Application by RiverOak Strategic Partners Ltd to reopen and develop Manston Airport
The Examining Authority's Fourth Written Questions and requests for information (ExQ4)
Published 21 June 2019

The following table sets out the Examining Authority's (ExA's) Fourth Written Questions and requests for information – ExQ4. The ExA's First Written Questions (ExQ1) were issued on 18 January 2019 [PD-007], its Second Written Questions (ExQ2) were issued on 5 April 2019 [PD-010b] and its Third Written Questions (ExQ3) were issued on 10 May 2019 [PD-014].

Figure 3.1
Masterplan - site layout

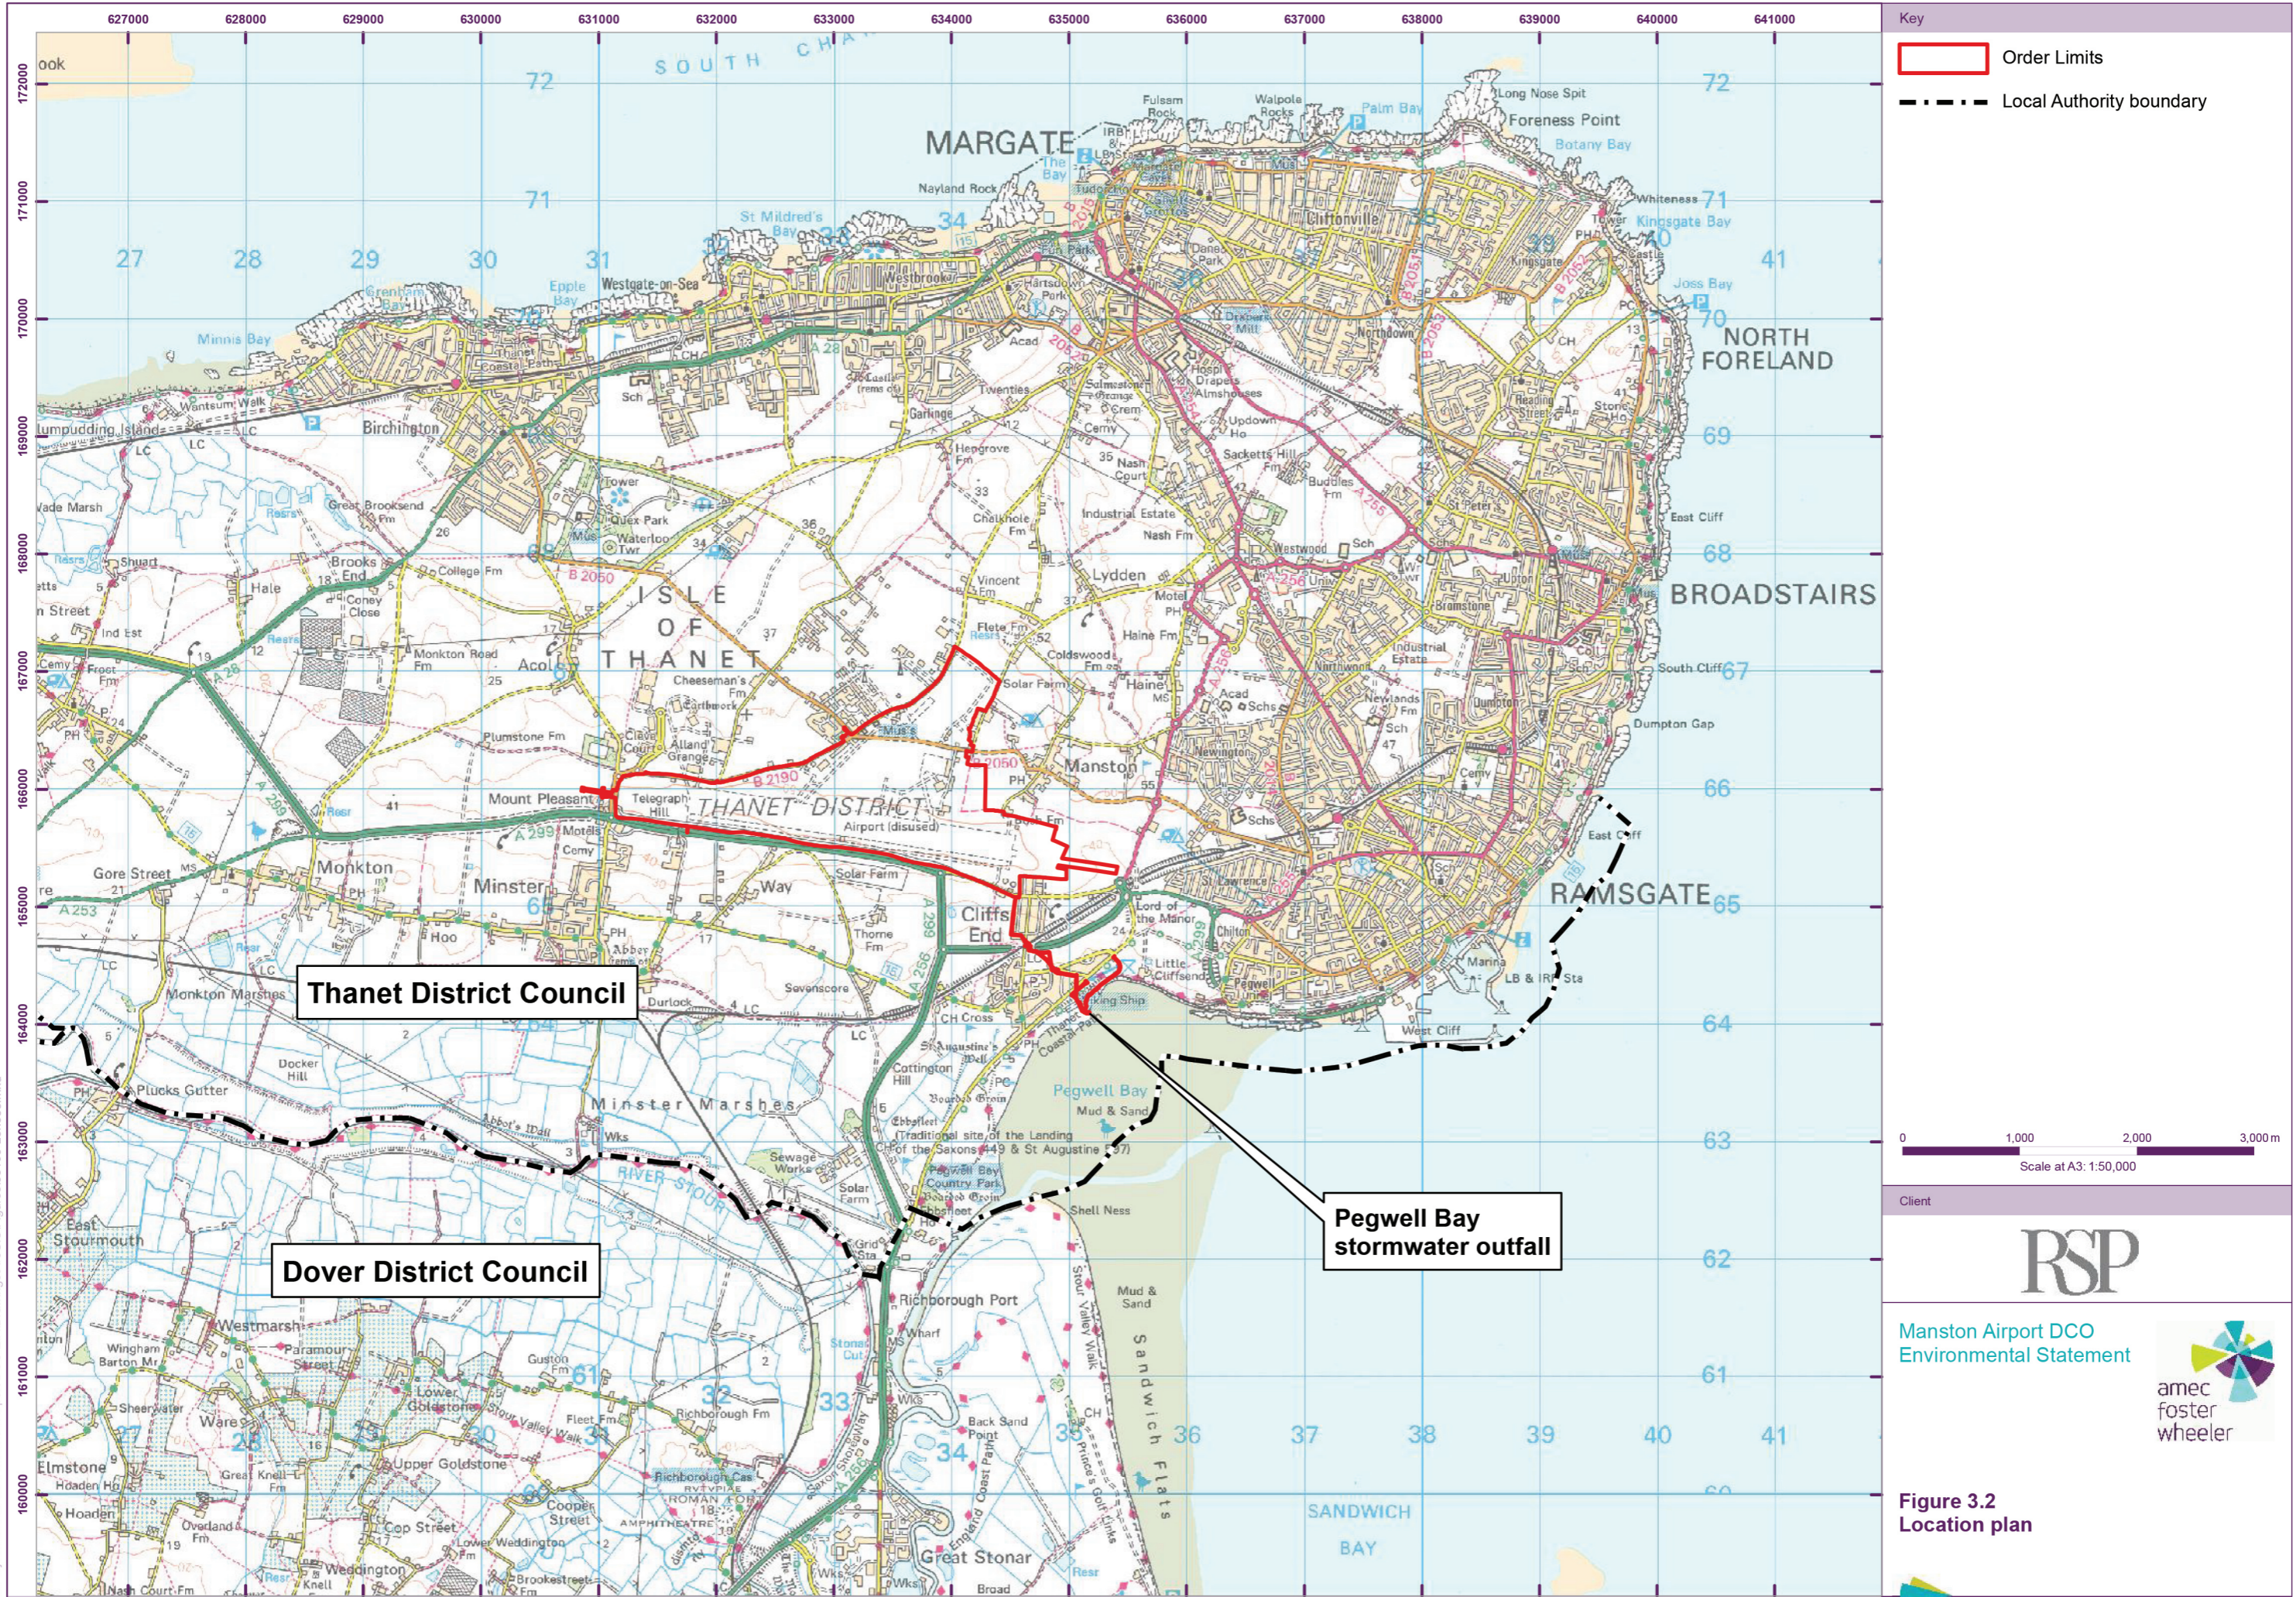
CA.4.4	The Applicant	<p>Associated Development</p> <p>The ExA notes that the definitions contained in the Fourth Schedule of the revised draft proposed s106 agreement state that:</p>

ExQ4	Question to:	Question:
		<p><i>“Northern Grass Area” means the area shown [] on the Manston – Haine Link Road Plan falling within the limits of the Development Consent Order which shall include a business park for Manston Airport.”</i></p> <p>Explain the use of the term “<i>business park</i>” in terms of the definition of Associated Development.</p>
CA.4.5	The Applicant	<p>Manston-Haine Link Road</p> <p>The Applicant’s response to Second Written Question TR.2.1 [REP6-017] stated: <i>“There are no changes necessary to the dDCO or revisions to the Work Plans as the Manston-Haine link road is not part of the DCO application.”</i></p> <p>As the Manston-Haine link road is not part of the application for development consent, justify the request to compulsorily acquire land and/ or rights over land which is not part of the DCO application.</p>
CA.4.6	The Applicant	<p>Reasonable alternatives to Compulsory Acquisition</p> <p>The Applicant has provided a further update of the Compulsory Acquisition Status Report at Deadline 8 on 14 June 2019 [REP8-008].</p> <p>This appears not to show any progress since the previous update and apart from land related to the fuel farm, an agreement with the 1948 Group Limited, and a fixed term agreement with David Steed in respect to plots 063 and 065 and your continued practice of treating statements of common ground as agreements, there seems to have been very little progress since the first version of this status report.</p>
